WEST SUSSEX COUNTY COUNCIL CONSULTATION

TO:	Arun District Council FAO: Maria Tomalova
FROM:	WSSC - Highways Authority
DATE:	29 June 2022
LOCATION:	Land at rear of Cedar End Eastergate Lane Eastergate PO20 3SJ
SUBJECT:	BN/65/22/PL Sever land and erection of 1 No bungalow with new vehicular access (resubmission of BN/14/22/PL). This application is a Departure from the Development Plan and is in CIL Zone 3 and is CIL Liable as new dwelling.
DATE OF SITE VISIT:	n/a
RECOMMENDATION:	Advice
S106 CONTRIBUTION TOTAL:	n/a

Proposed Site Plan
1:200

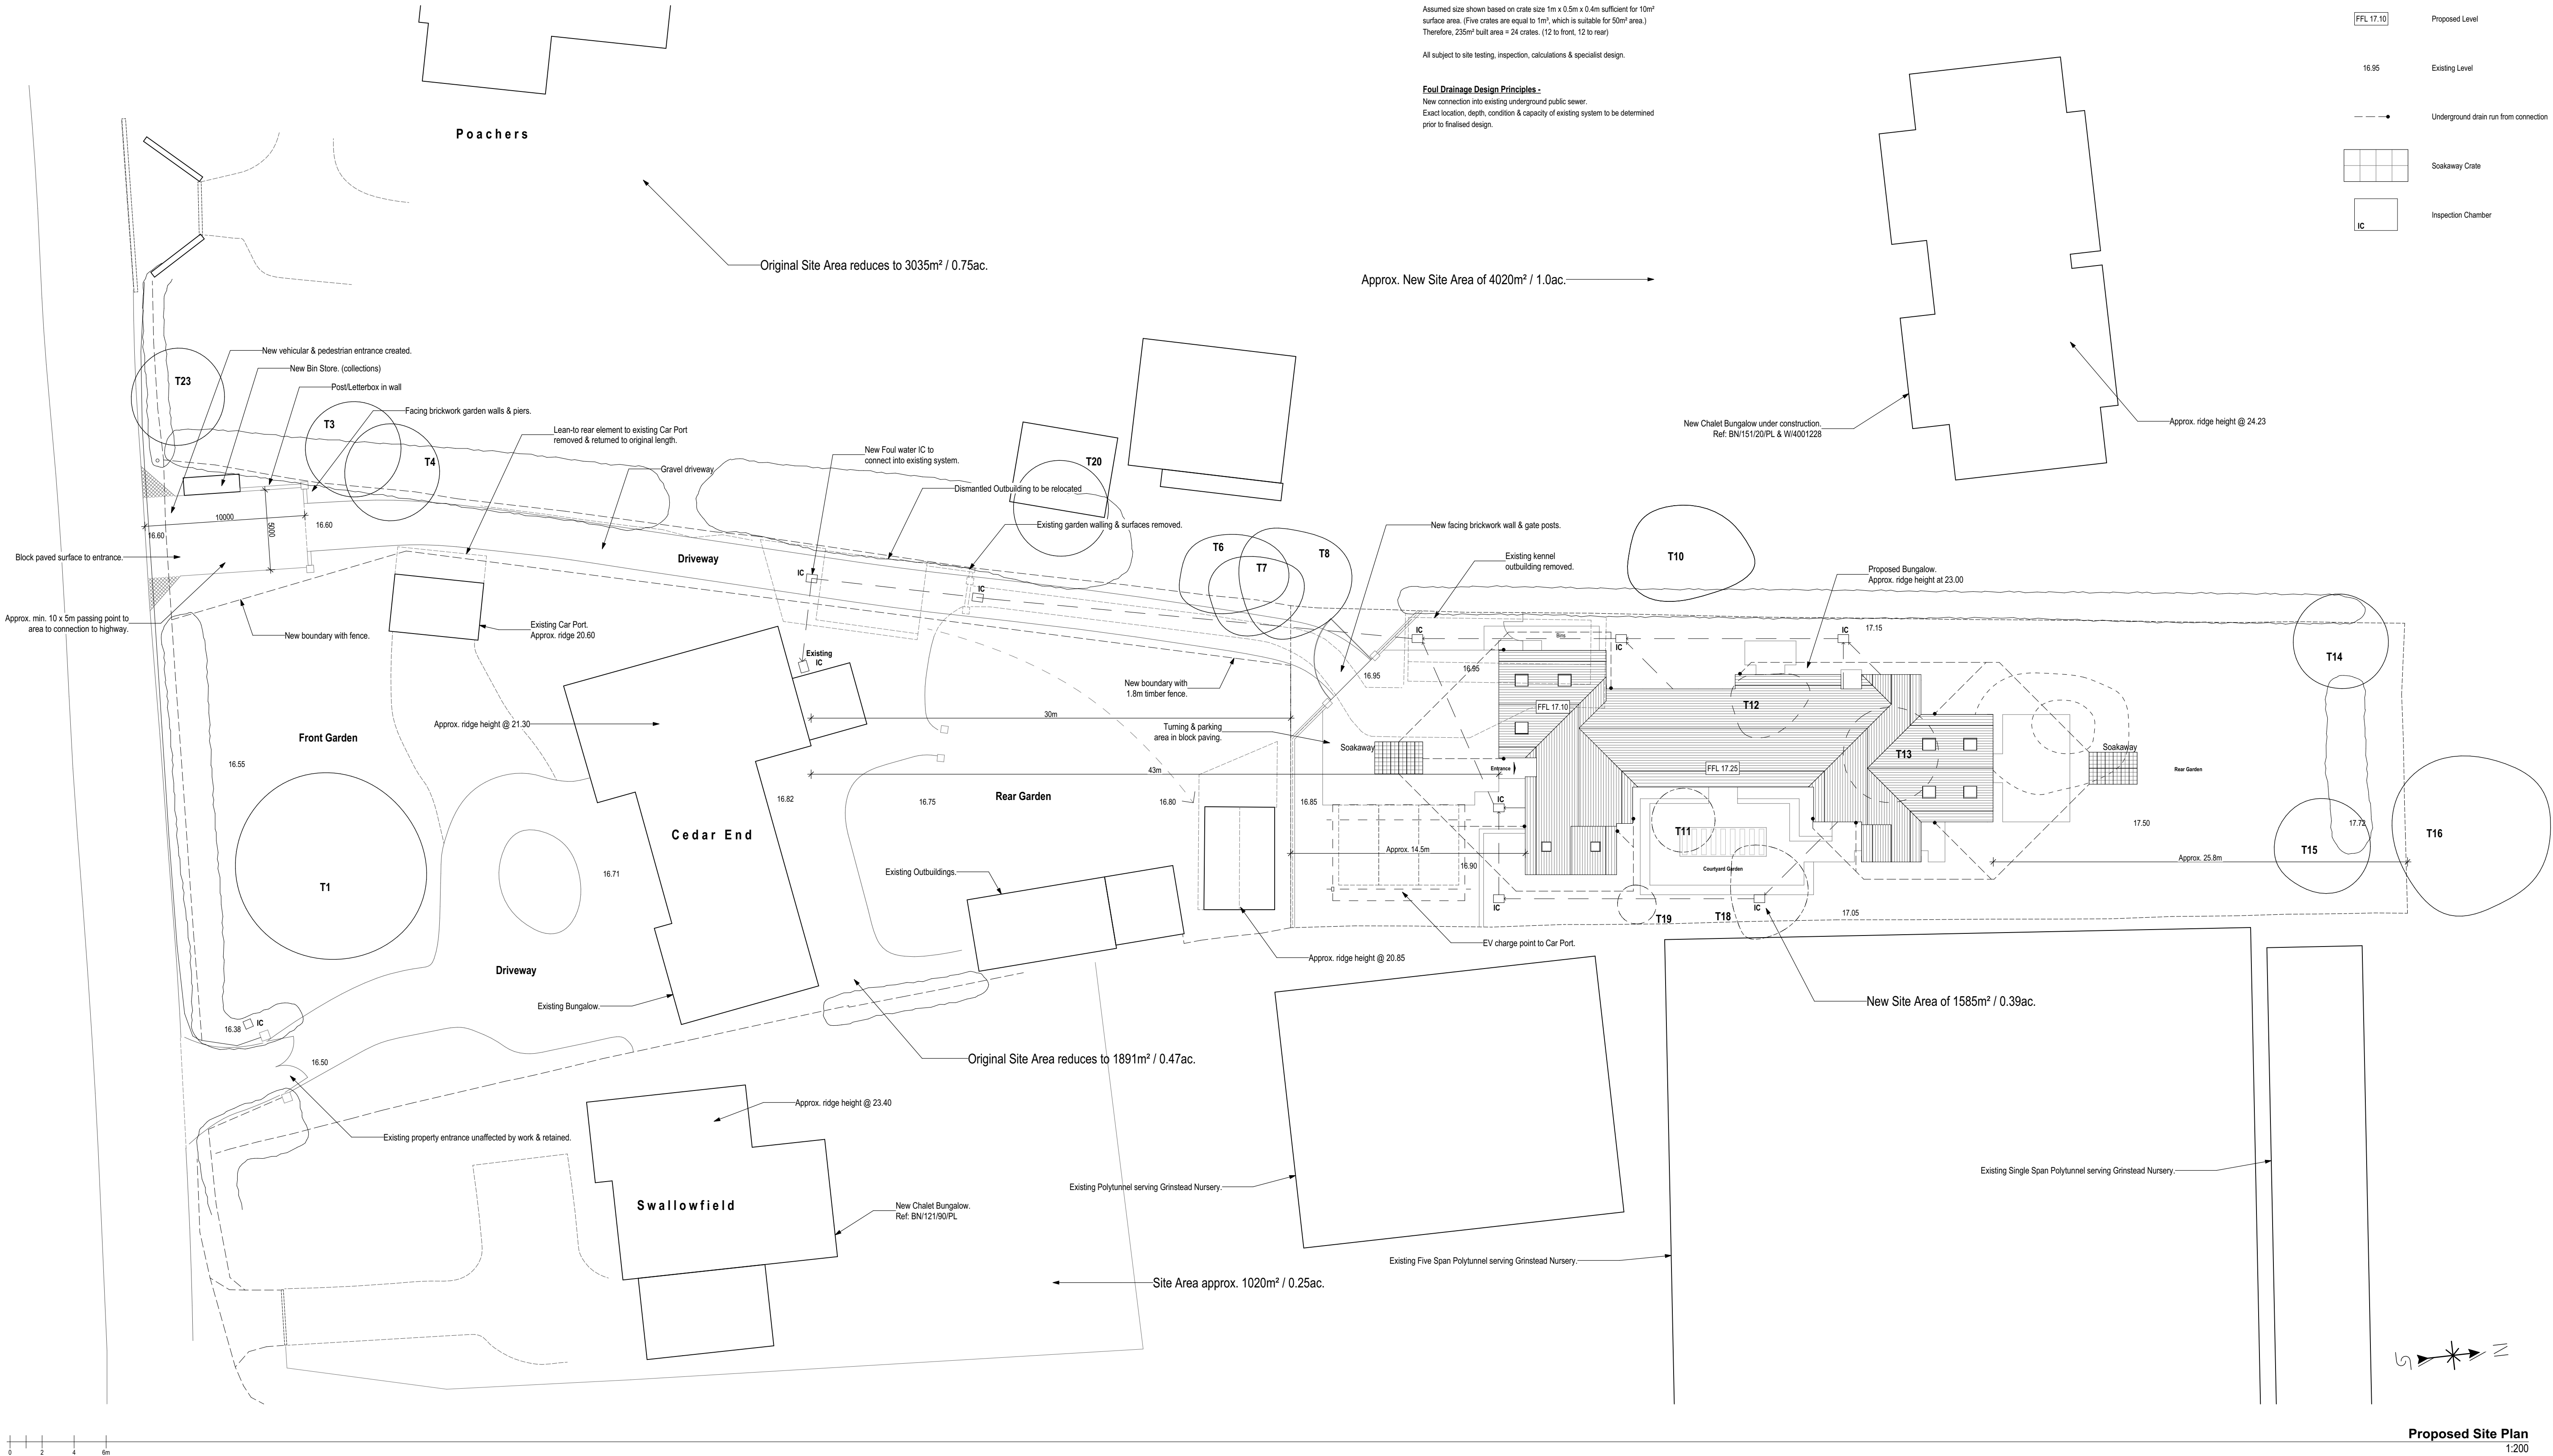
The applicant has provided Vehicle Crossover (VCO) details. No dimensions of the access have been annotated. The applicant should be made aware that VCO's under 4.5 metres or over 6.4 metres are generally not accepted at the licensing stage. Though in this instance, such a provision is not considered a highway safety concern. The applicant

should be mindful that this may result in, if successful, a planning permission that cannot be implemented. Therefore, the applicant is recommended amending the plans to show a kerbside VCO of between 4.5 – 6.4 metres. Details of which can be secured via a suitably worded condition found below.

The applicant has provided parking for 3 cars. The LHA raise no concerns over this provision.

The applicant has provided space for domestic cars to perform a turn on site. The LPA may wish to consult WSCC regarding fire appliance access.

No part of the development shall first be occupied until such time as the vehicular access has been constructed in accordance with plans and details **to be** submitted to and approved in writing by the Local Planning Authority.

No part of the development shall be first occupied until the car parking has been constructed in accordance with the approved site plan. These spaces shall always thereafter be kept for their designated purpose.

No part of the development shall be first occupied until the vehicle turning space has been demonstrated within the site in accordance with plans and details **to be** submitted to and approved by the Local Planning Authority. This space shall always thereafter be kept for their designated use.

Land r/o Cedar End, Eastergate ^ Maximum Visibility Splays ^ 1:2000@A3 ^ 1671-SYM-00-ZZ-DR-A-0214 P01

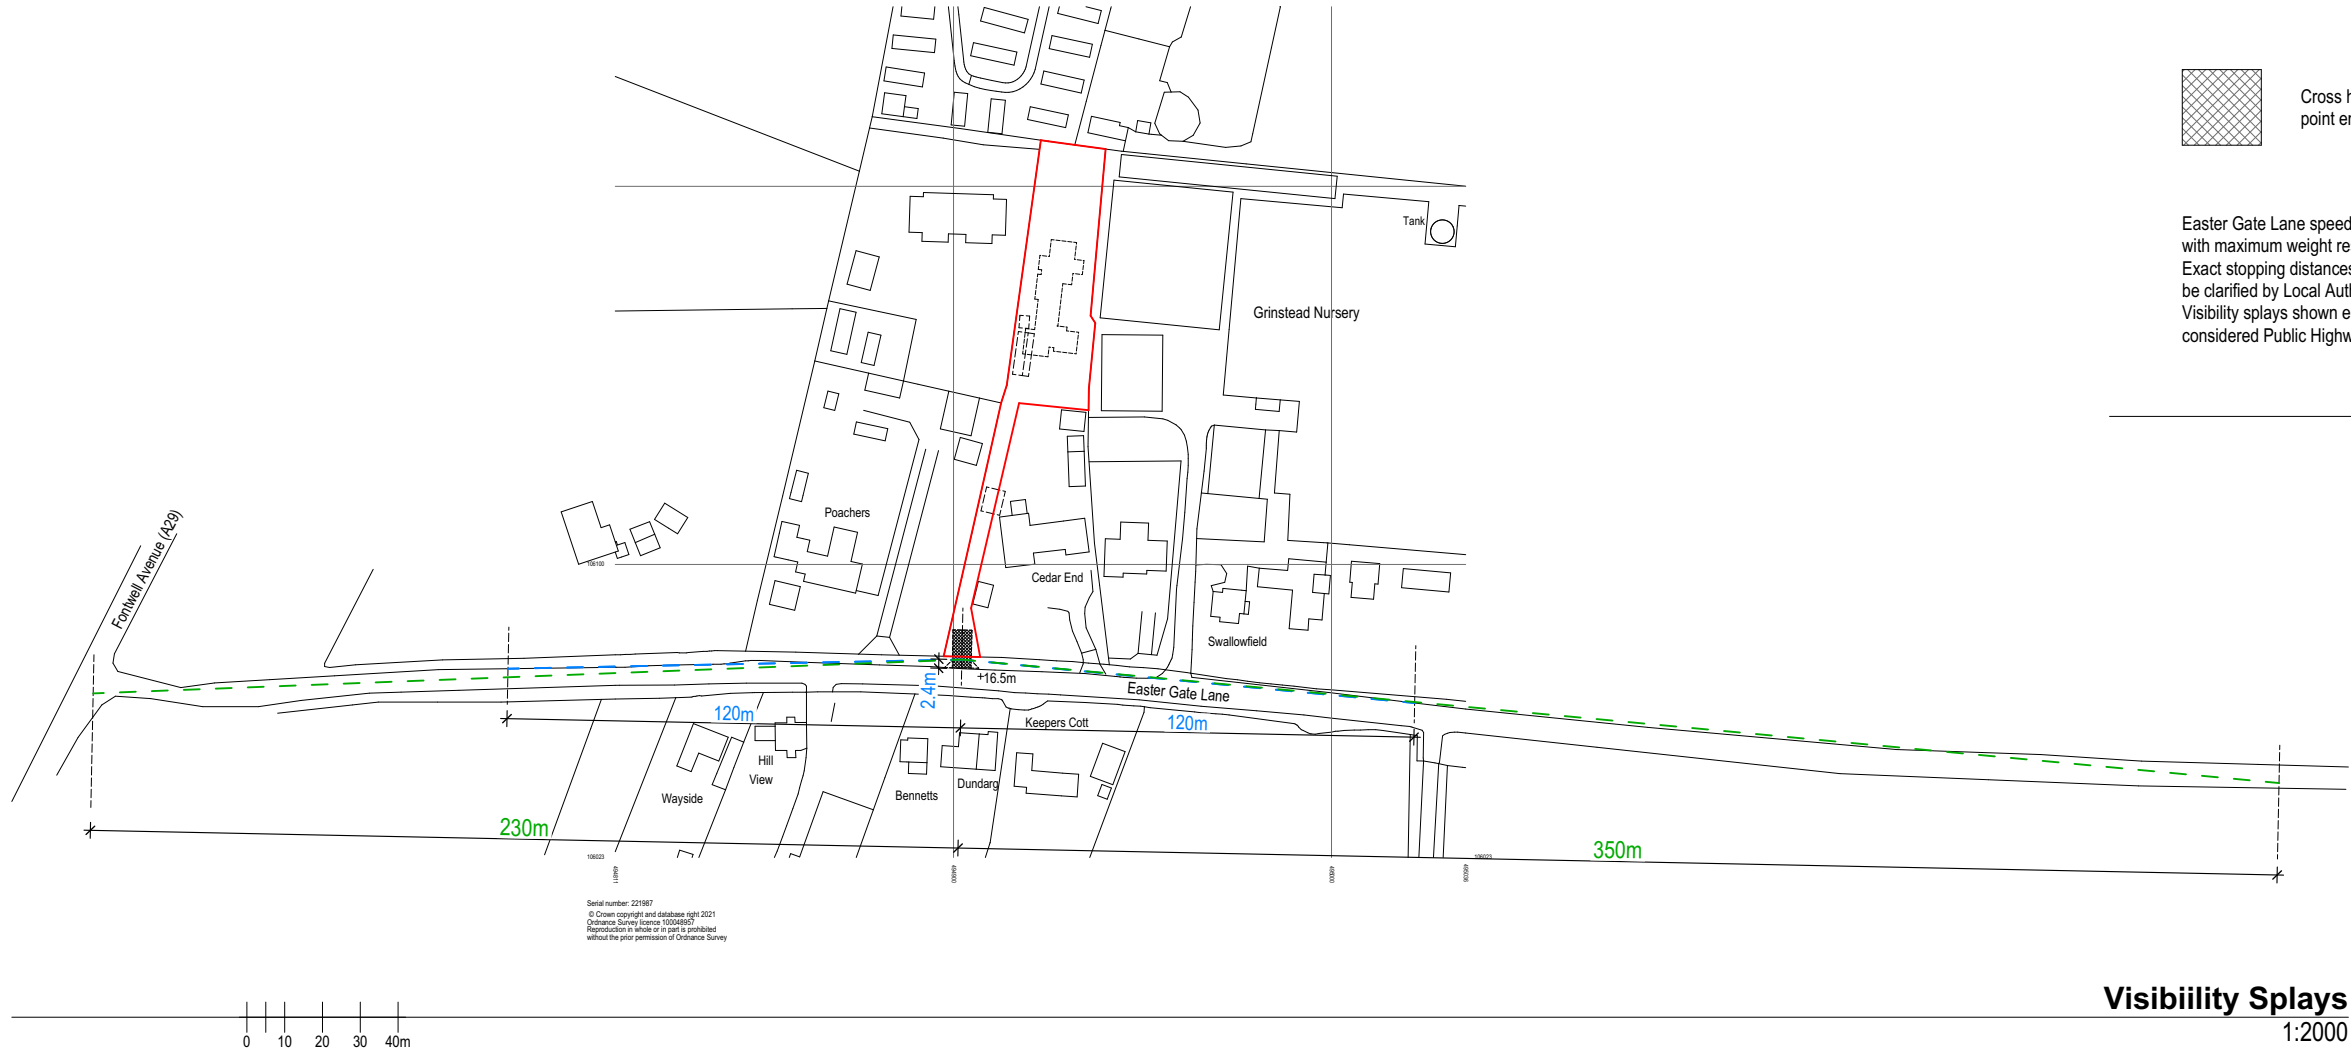
WSCC local mapping indicates that vehicle visibility can be accommodated solely within the highway boundary.

The applicant has provided pedestrian visibility splays.
